EXHIBIT SHOWING DIFFERENCES IN MAP DATED MAY 23, 2017 AND CURRENT SUBMITTAL

MERCER ISLAND FILE NO. SUB17-006

PRELIMINARY
NFH RESIDENCE LOT LINE REVISION
(LOT CONSOLIDATION)
POR. OF GOV. LOT 1, SEC. 1, TWP. 24 N., RGE. 4 E., W.M.

LOT LINE REVISION (LOT CONSOLIDATION)
FOR
NFH RESIDENCE
8000 SE 20TH ST
MERCER ISLAND, WA 98040

PRELIMINARY
NFH RESIDENCE LOT LINE REVISION
(LOT CONSOLIDATION)
 POR. OF GOV. LOT 1, SEC. 1, TWP. 24 N., RGE. 4 E., W.M.

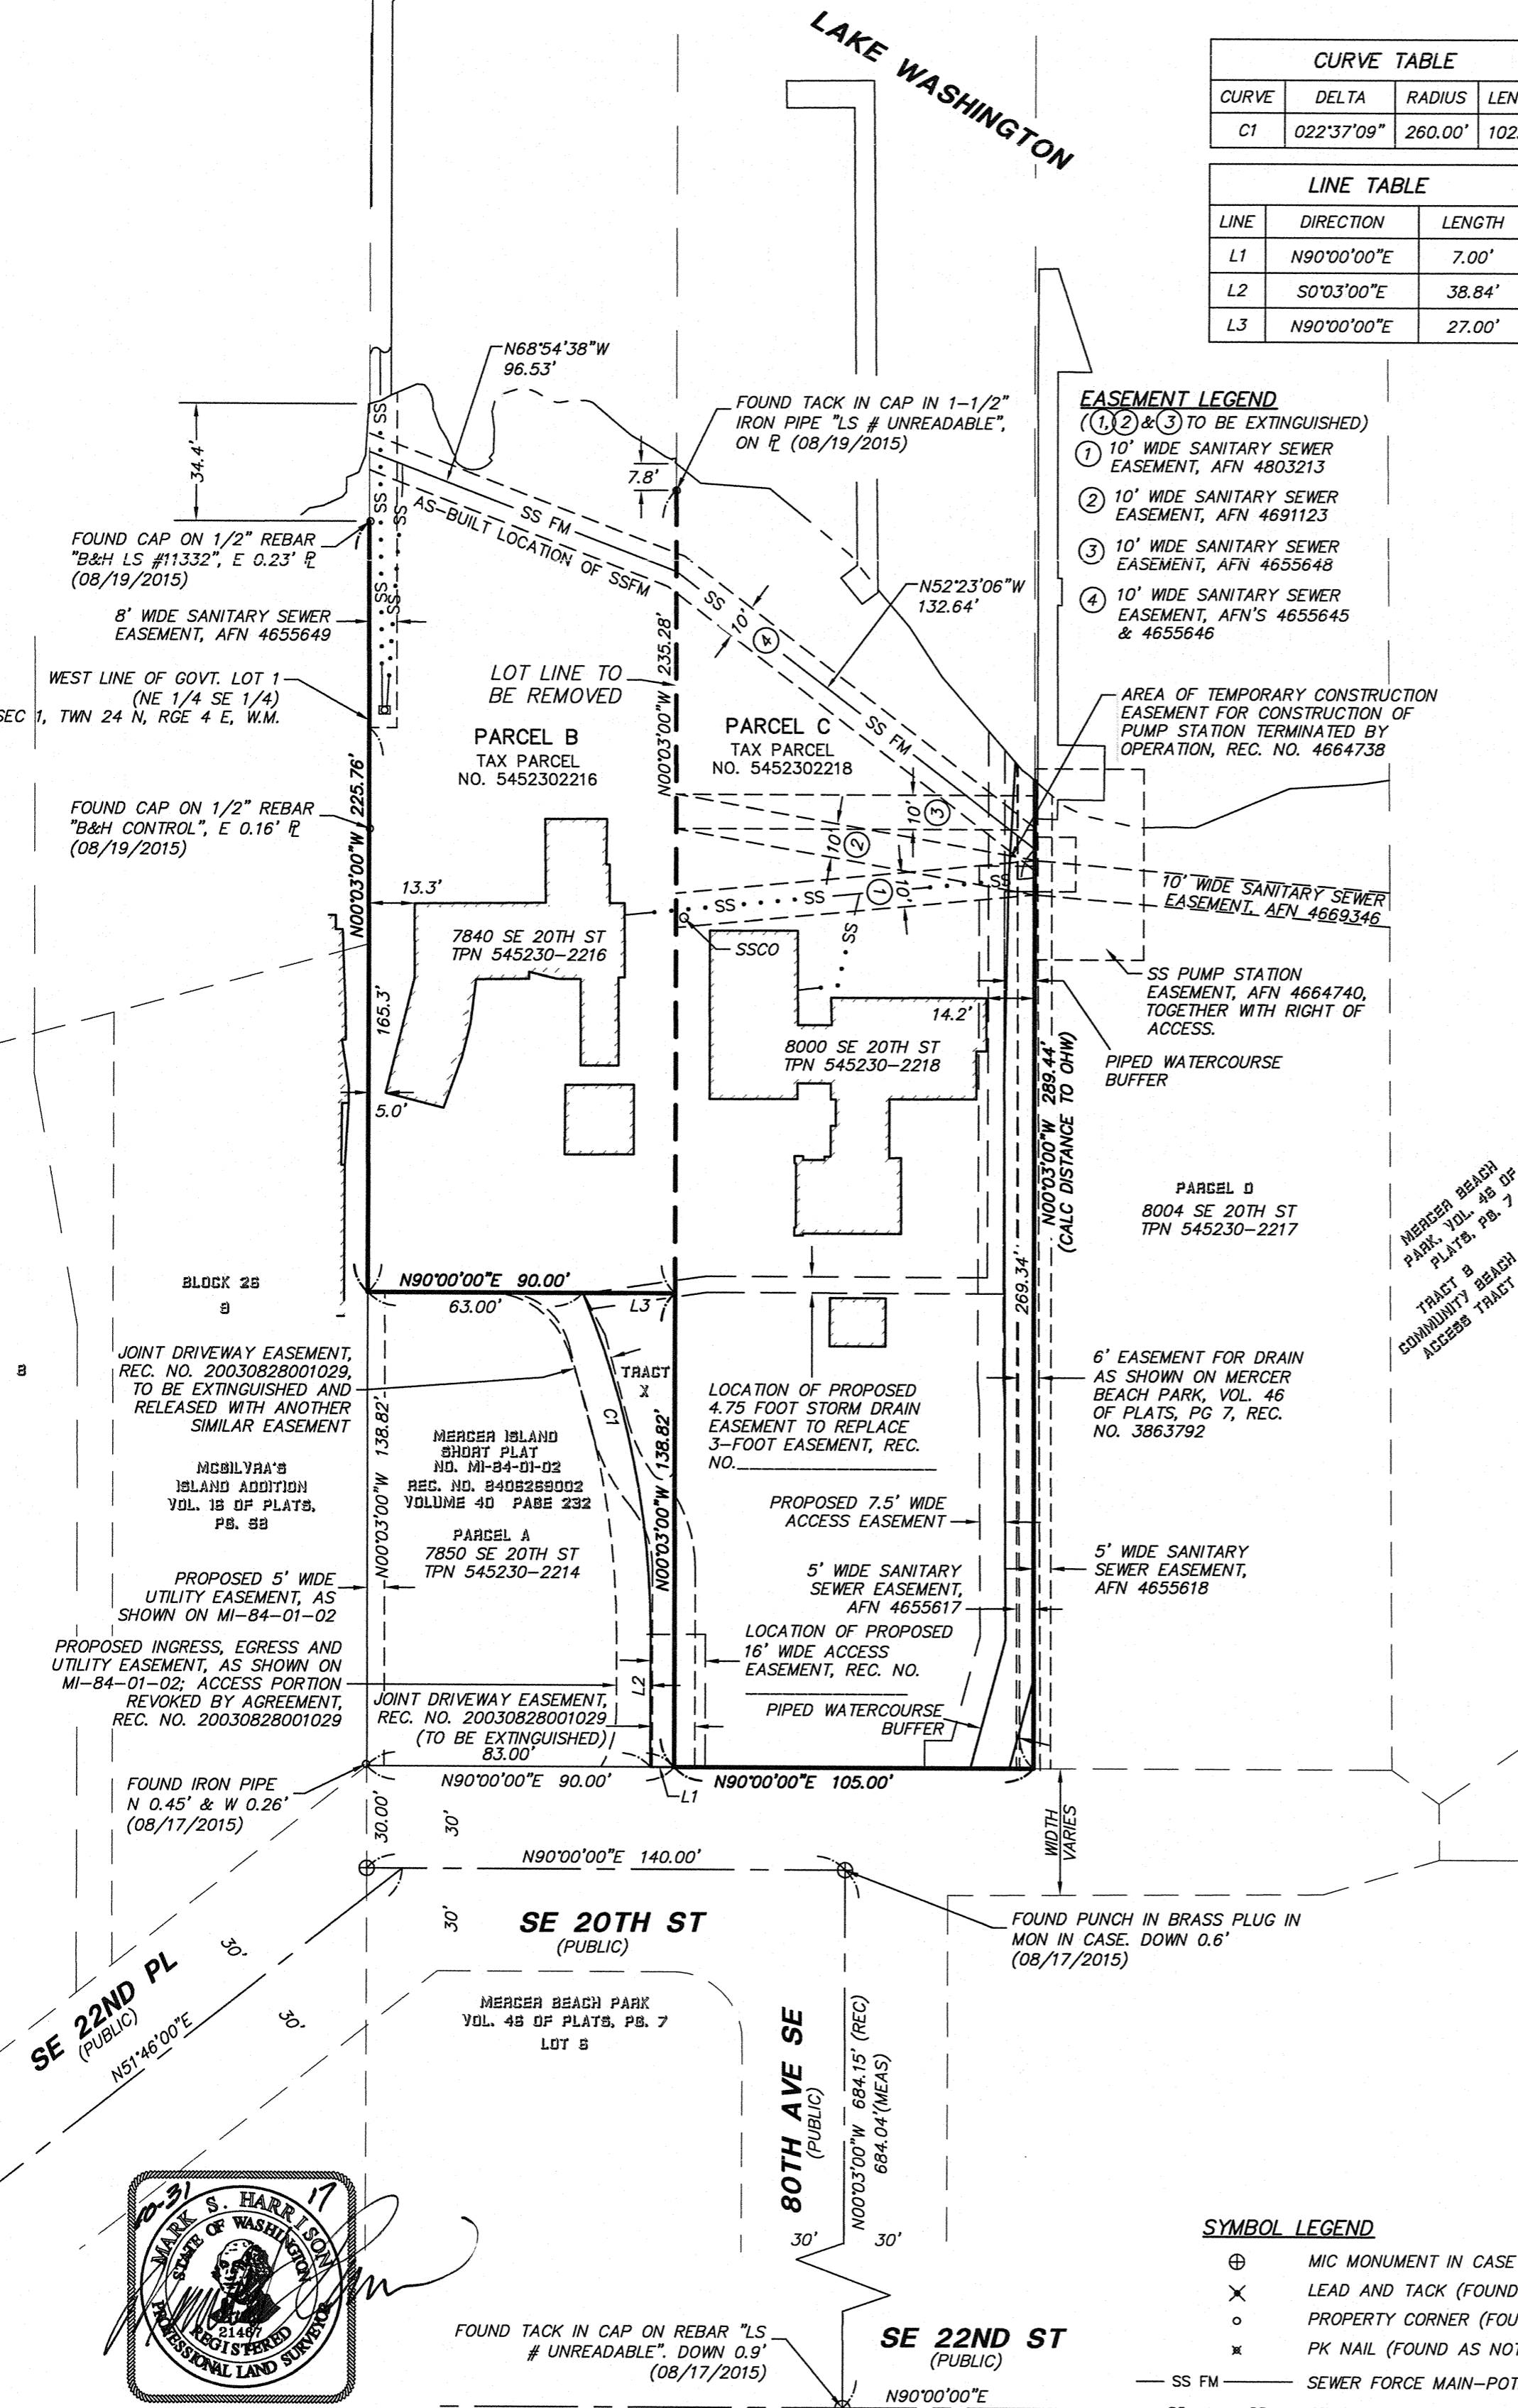
ADDED NOTE RE EASEMENT TERMINATION

NOTE REVISED TO REFLECT SS ASBUILT

LOCATION MOVED WESTERLY PER NEW CIVIL DESIGN

ADDED RECORDING INFORMATION

ADDED ACCESS EASEMENT
ADDED BUFFER

NOTES
REVISED
